Your reference      SSD 6407  
Our reference:      EF15/2643, DOC15/432054-03  
Contact:            J Goodwin 9995 6838

#### **SSD 6407 – WEST HOXTON COMMERCIAL PRECINCT EIS**

**ATTACHMENT A**  
**- ENVIRONMENT PROTECTION AUTHORITY COMMENTS -**  
**WEST HOXTON COMMERCIAL PRECINCT**

Noise Logging Data (marked up with Badgerys Creek weather data)

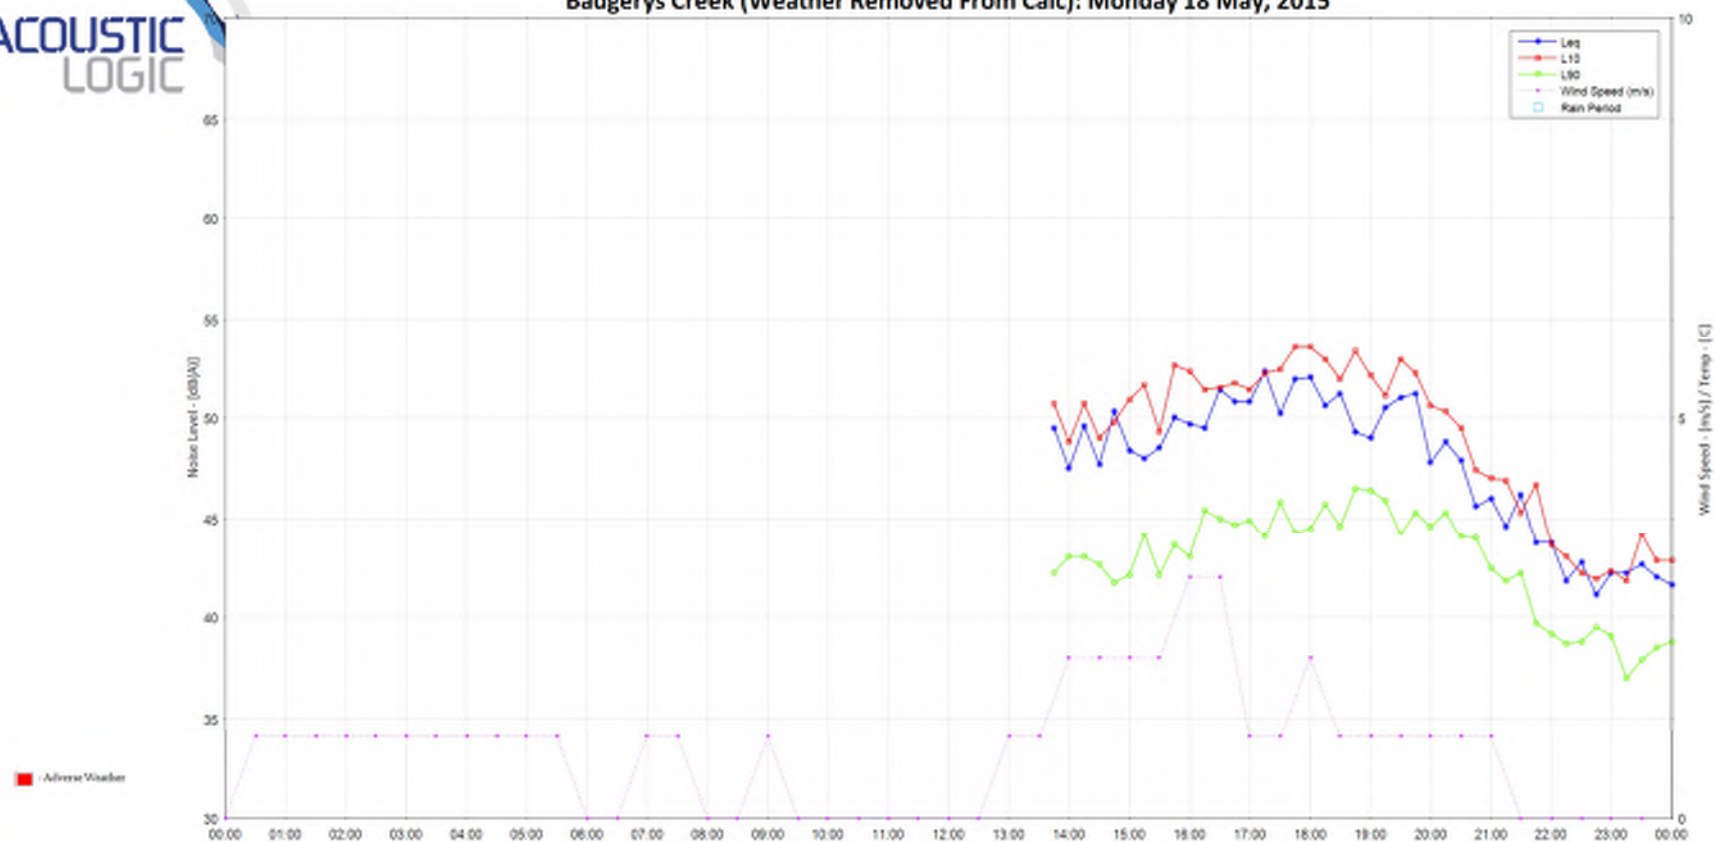
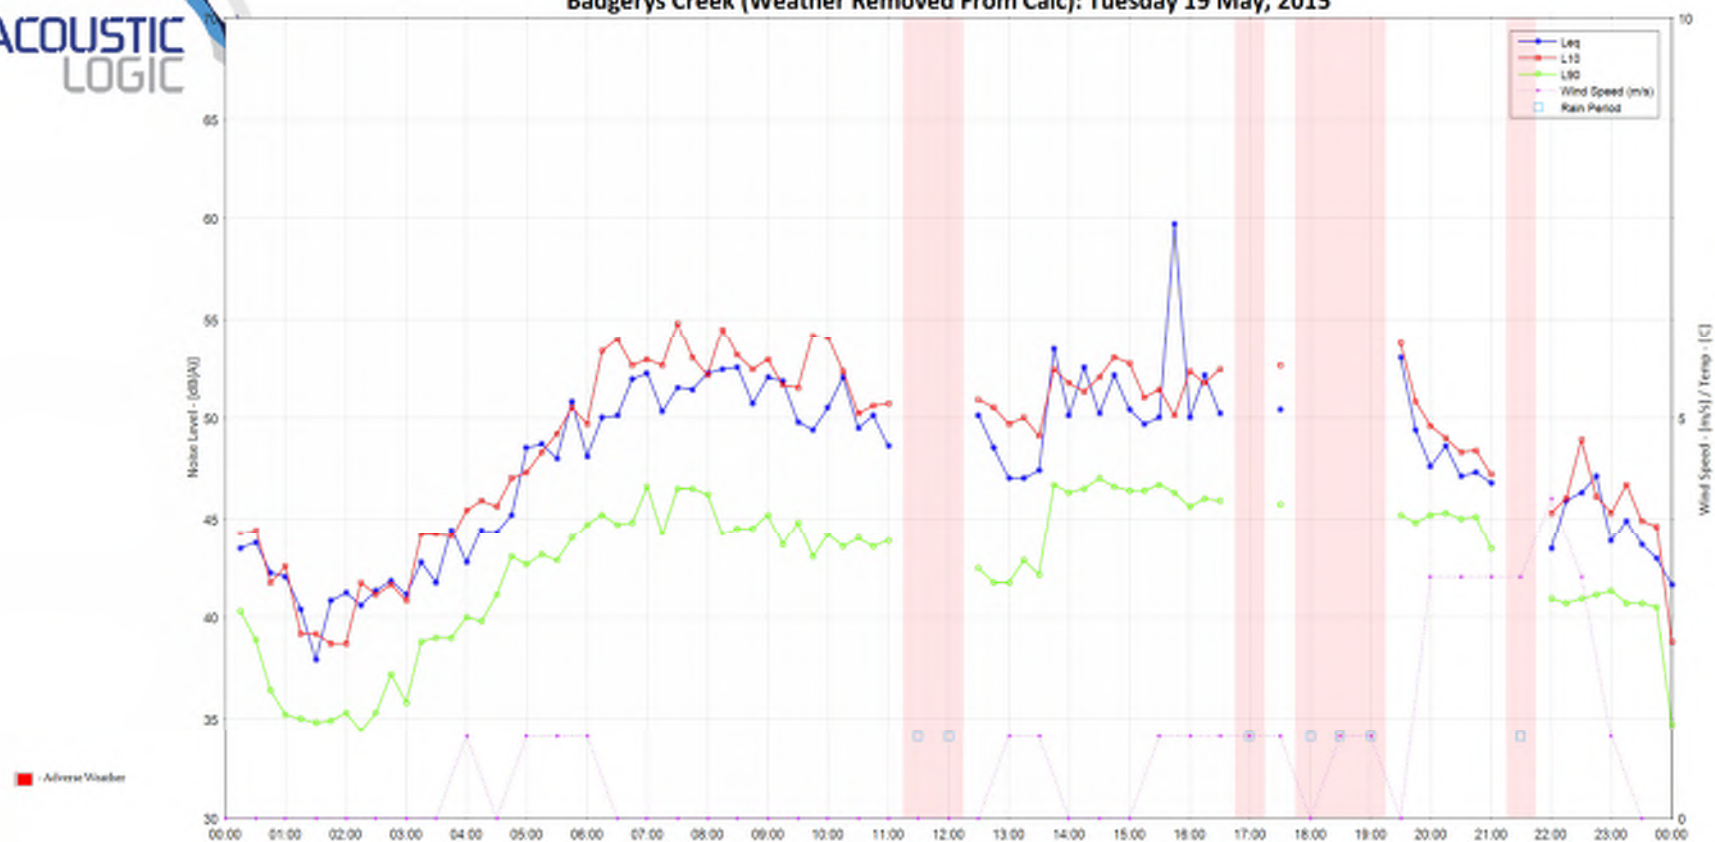
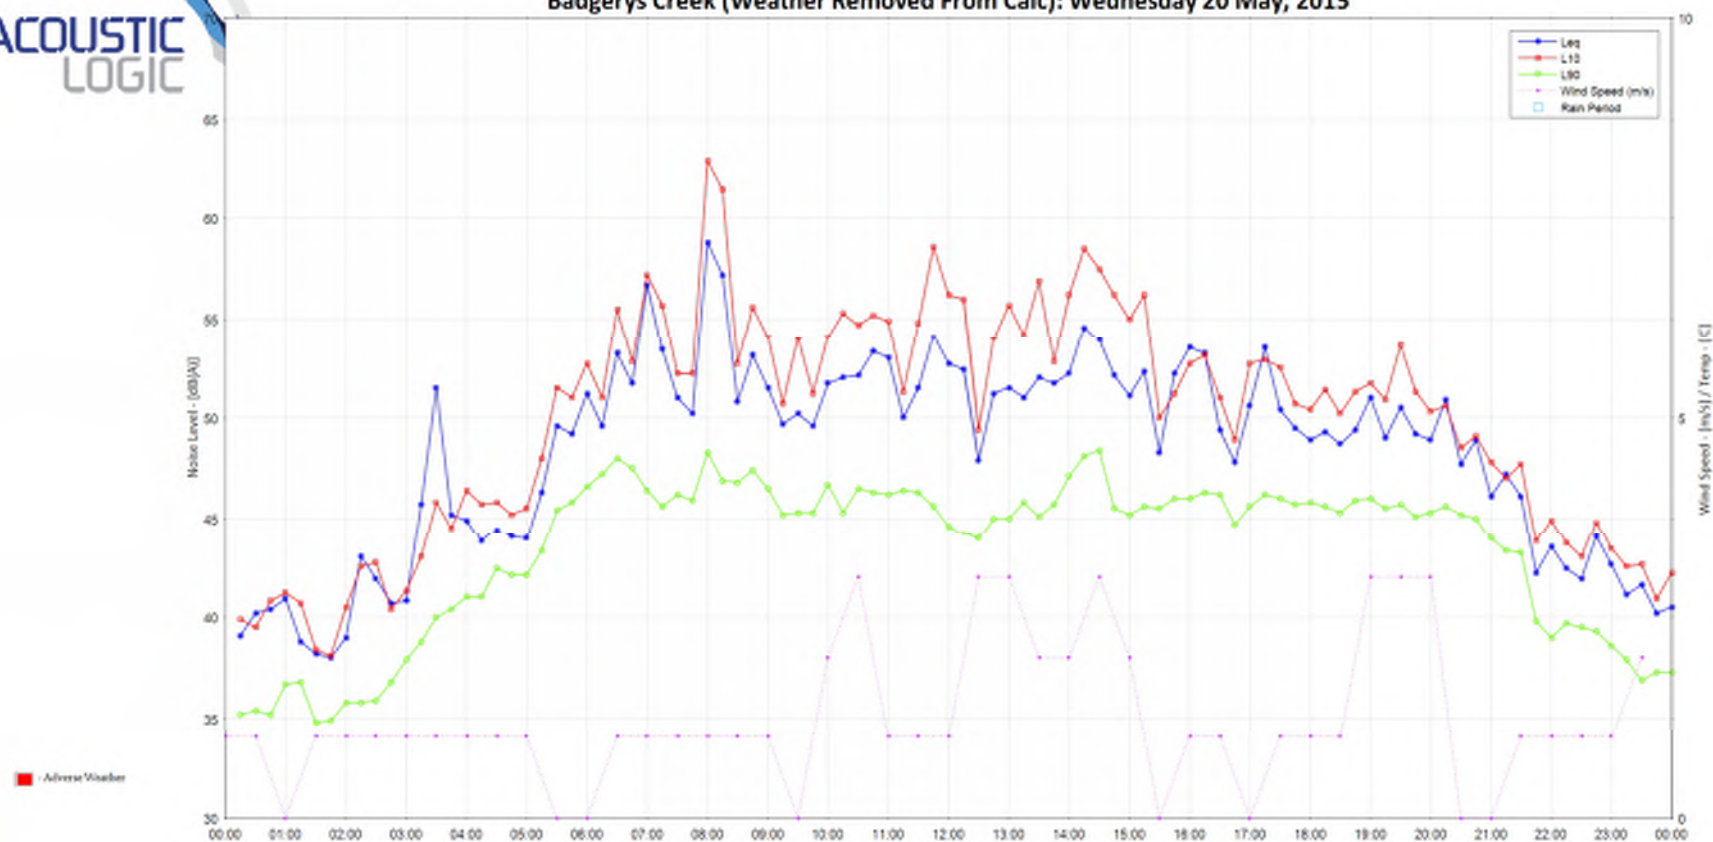
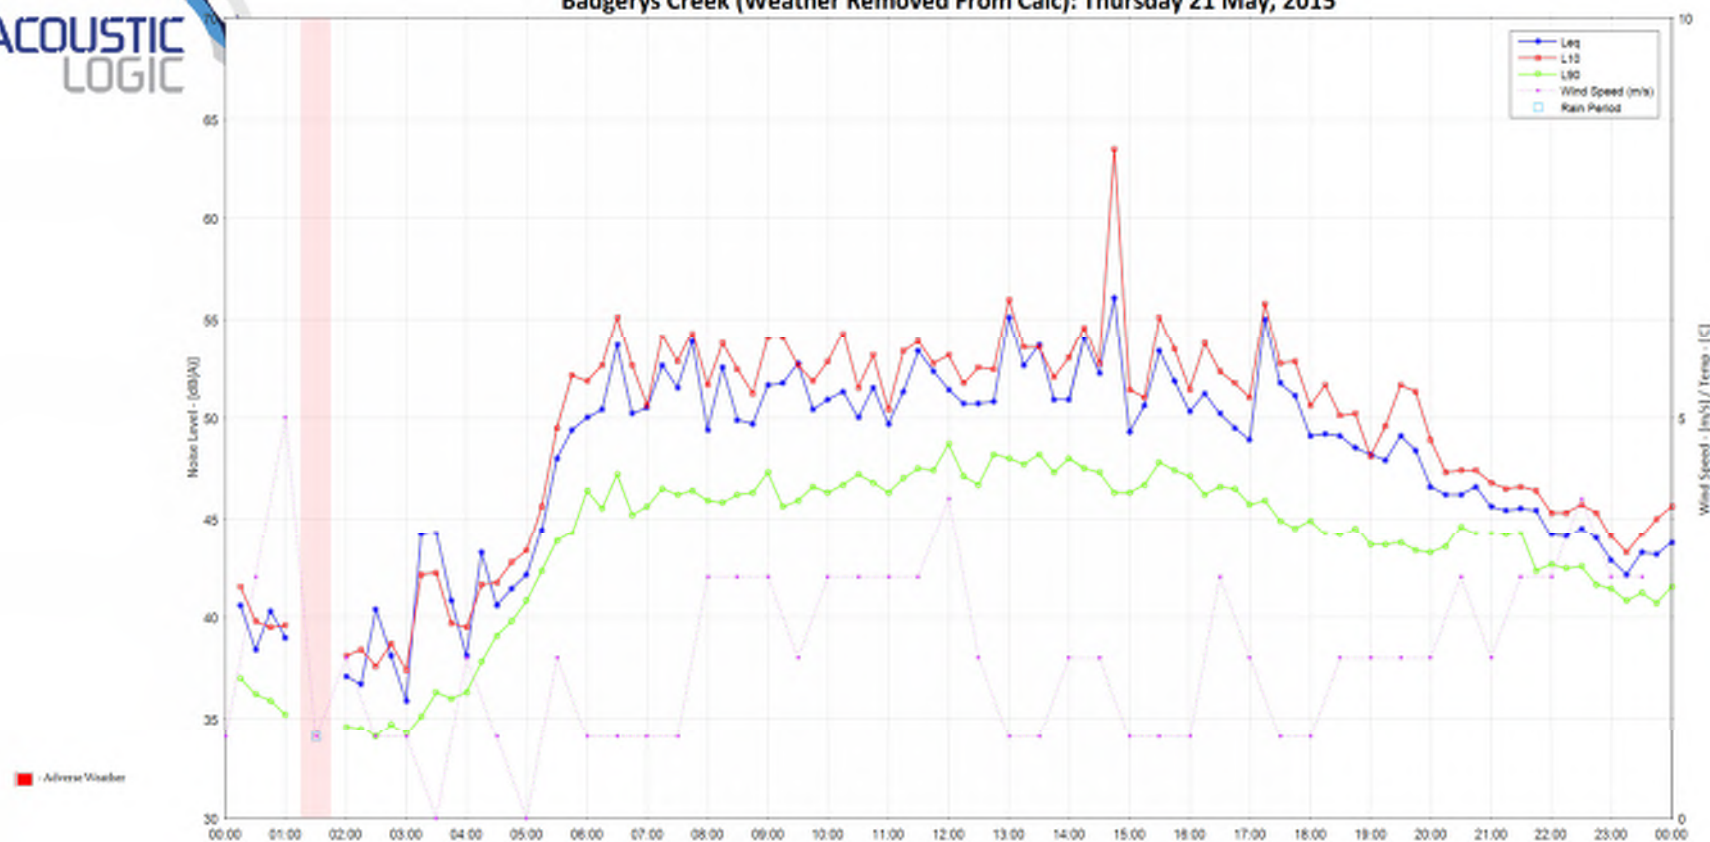
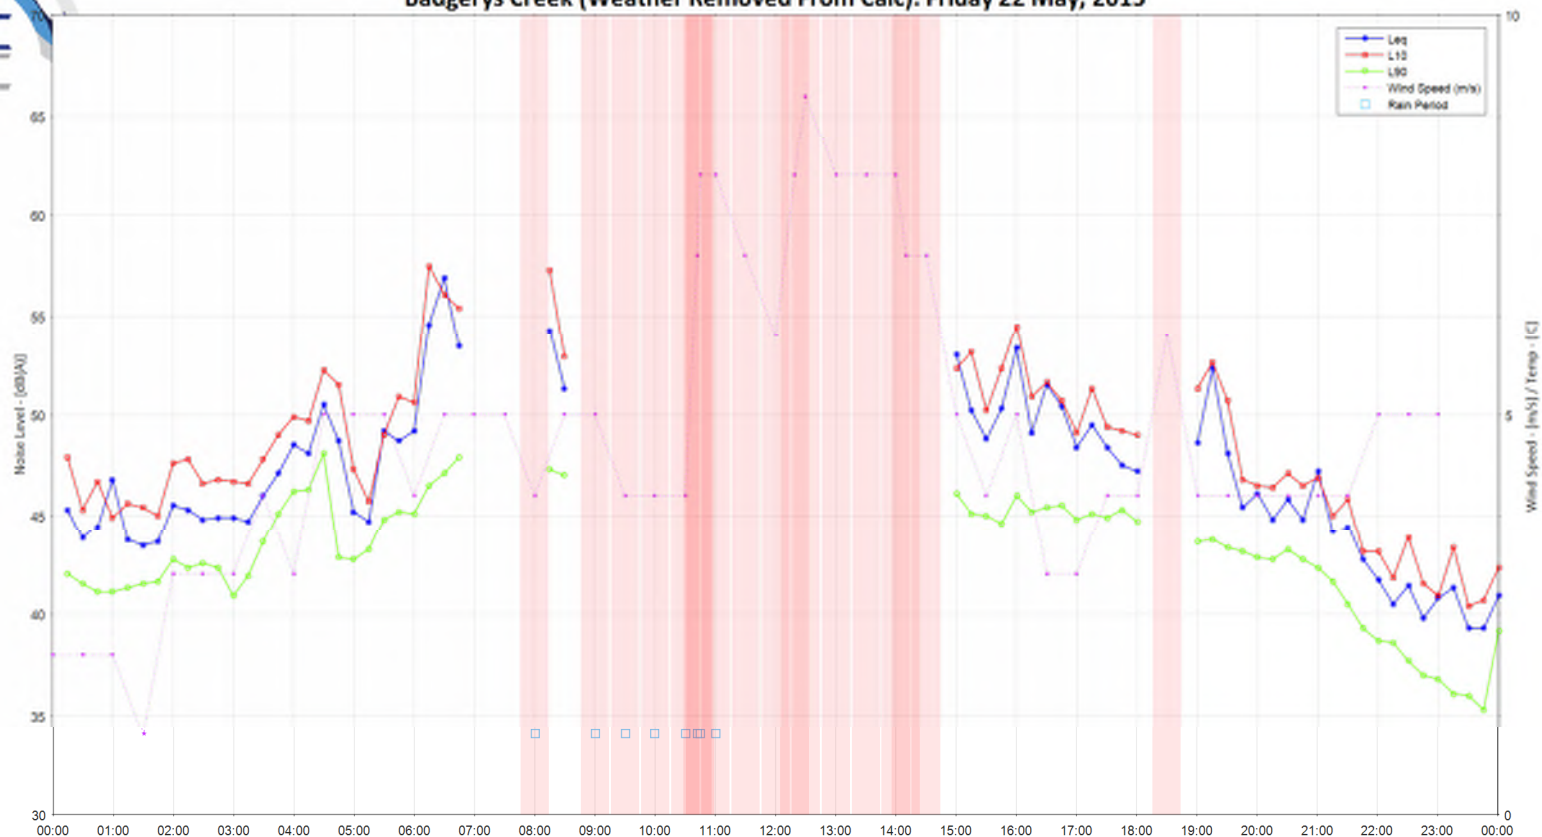
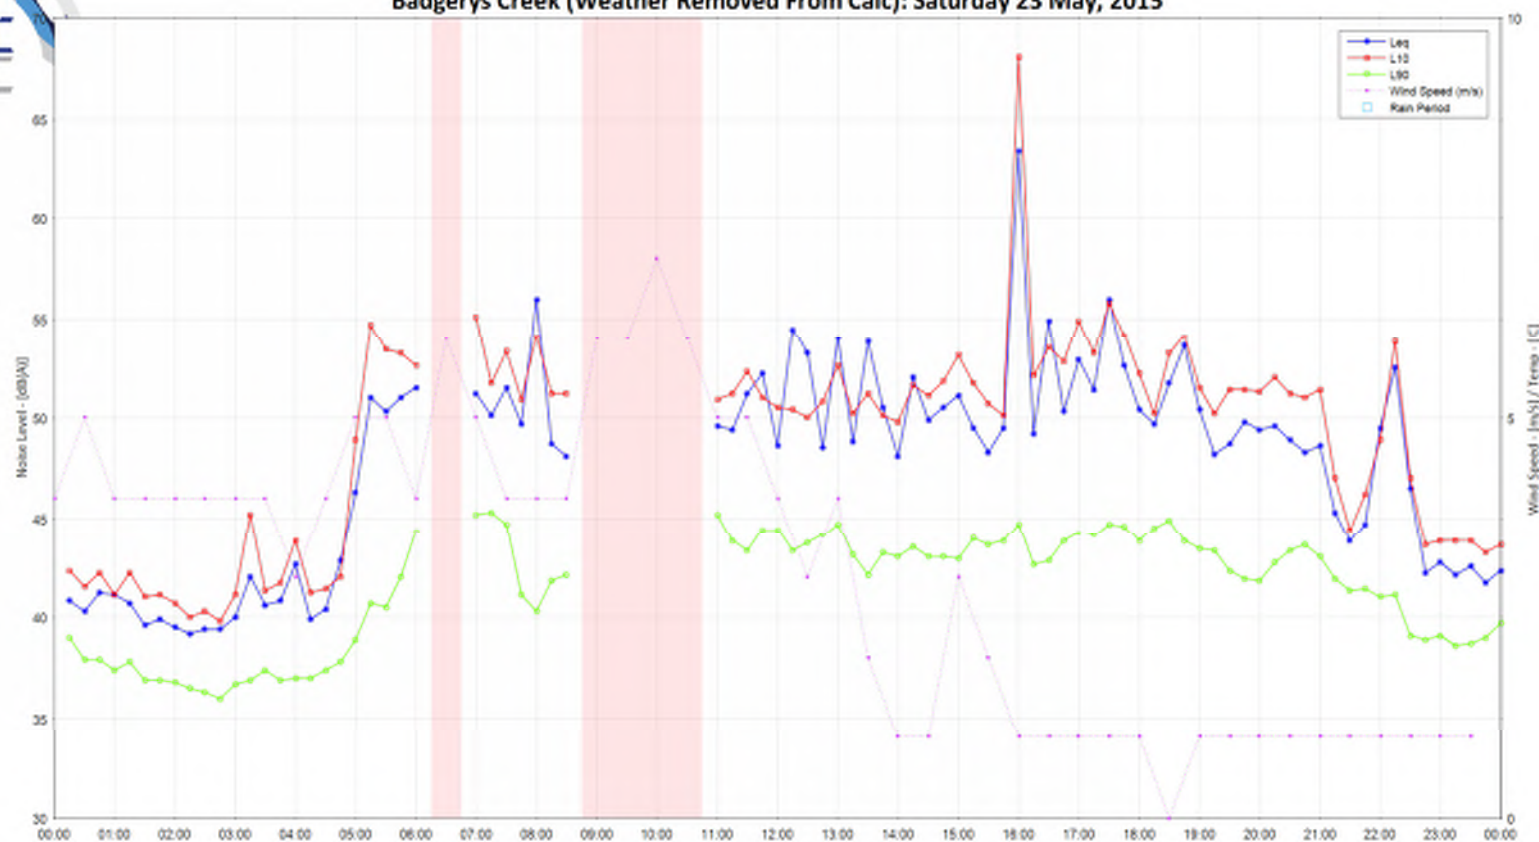
Section 4 to EIS Appendix 10 indicates that background noise monitoring was undertaken "... between 18 and 24 May 2015 ...". The Bureau of Meteorology Badgery's Creek automatic weather station indicates that-

- (a) rain was recorded each day from 19 May 2015 to 23 May 2015 inclusive,
- (b) wind gusts were recorded in excess of 18 kilometres per hour on each day from 18 May 2015 to 23 May 2015 inclusive (with gusts in excess of 18 kilometres per hour at 9:56 pm on 19 May 2015 and 12.49 am on 21 May 2015), and
- (c) wind speeds in excess of 18 kilometres per hour were recorded at 9.00 am and 3.00 pm on 22 May 2015 and again at 9.00 am on the following day.

Accordingly, the EPA considers that some of the noise monitoring data obtained between 18 and 24 May 2015 should be excluded for the purposes of establishing background noise levels, which would result in there being less than the 7 days of valid monitoring recommended in the NSW Industrial Noise Policy (INP). Thus, the proponent should undertake further noise monitoring to obtain not less than 7 days of valid noise monitoring data as the basis for establishing background noise levels (especially night-time levels) in the locality. Alternatively, the proponent may adopt a night-time background noise level of 30 dBA.

The proponent be required to adopt a night-time background level of 30 dBA or undertake further noise monitoring to obtain 7 days of valid data under acceptable meteorological conditions, (as described in section 3.4 of the NSW Industrial Noise Policy) for the purpose of –

- (a) revising the evening and night-time background noise levels in the locality, and
- (b) re-assessing predicted noise impacts.
